Please see Action Sheet

Drawing 2 / 4	
All drawings are copyright of BKM architectural plans and drawings service and may not be reproduced without prior permissions

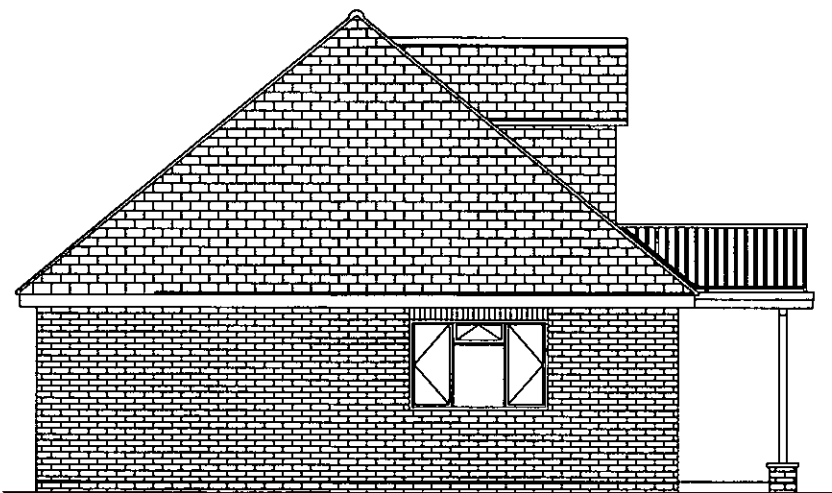
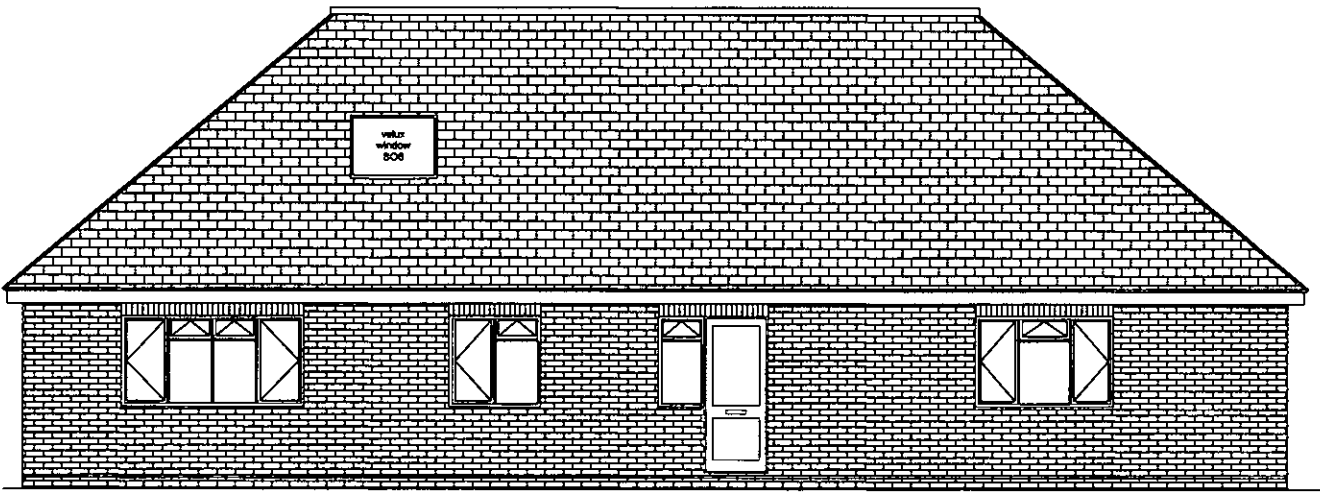
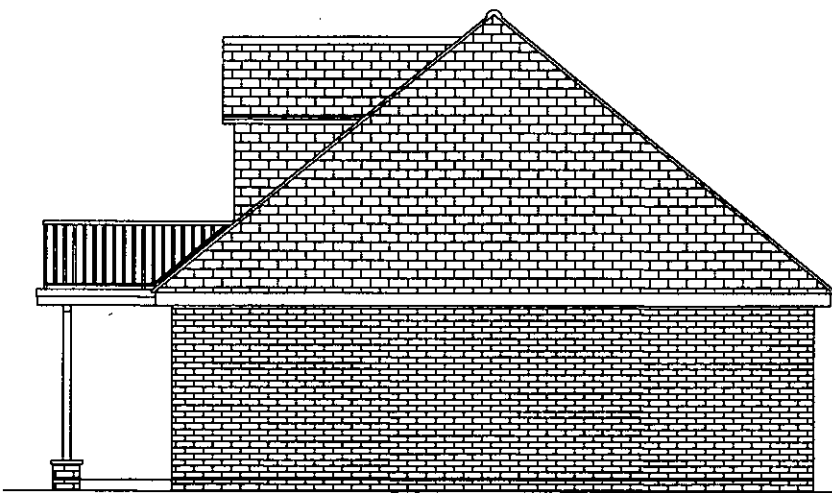
Can you amend the drawings to mark it as obscure glazed. Can you also ensure that the sill height is at least 1.7m and can you show this on the section drawing.

I note on the plans that a velux window is shown in the rear elevation which could potentially permit overlooking of the neighbours property. Is this window strictly necessary?

The velux window was chosen in preference to a dormer, being a bathroom it will have to have obscure glass (not noted on plan). I will have to rely on your discretion, please let me know if a revised plan is required.

Drawing 2 / 4	
All drawings are copyright of BKM architectural plans and drawings srevice and may not be reproduced without prior permissions

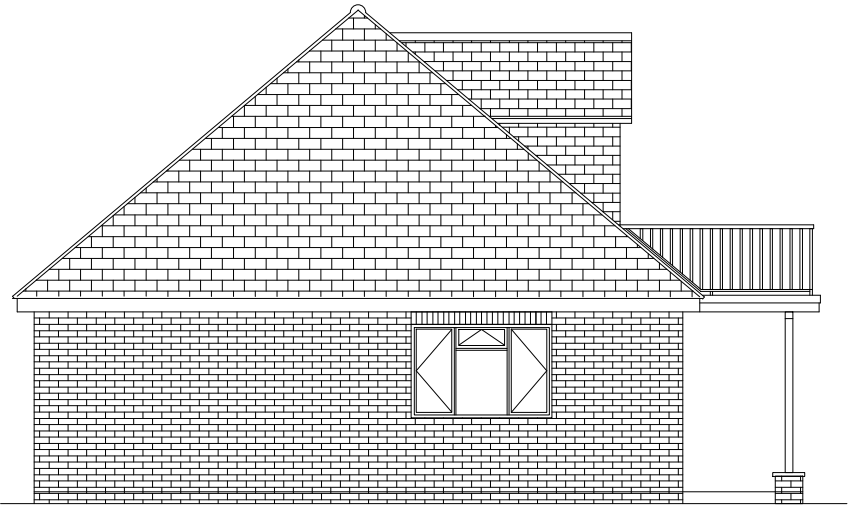
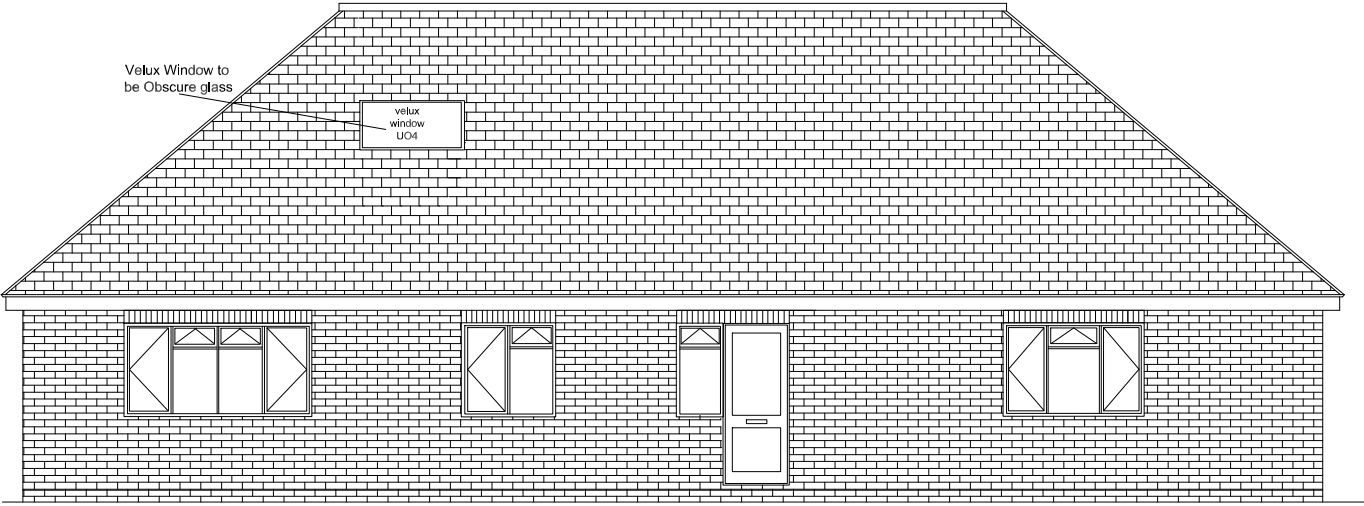
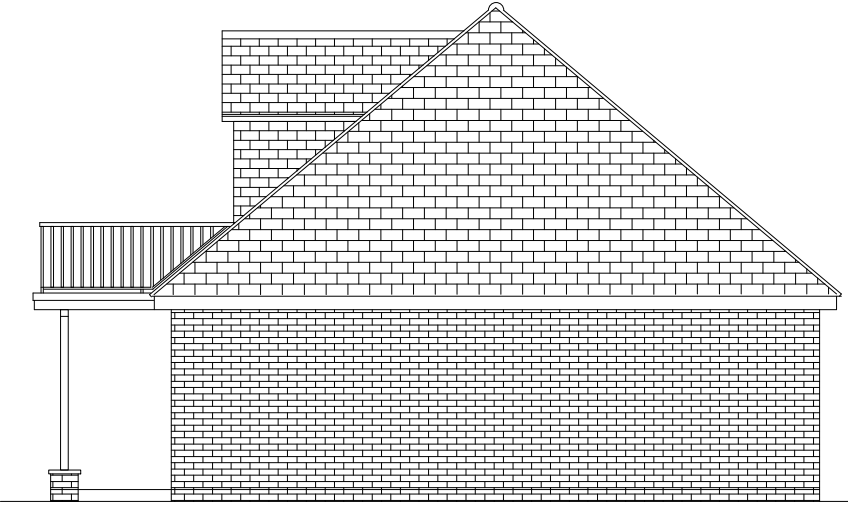
Thanks for these. However, for our purposes (the purposes of protecting the amenities of the neighbouring property), we need the sill height of the velux to be 1.7m above the floor level when measured vertically (i.e. so only those people greater than 170cm in height would be able to see out of the window. Us this possible to provide?
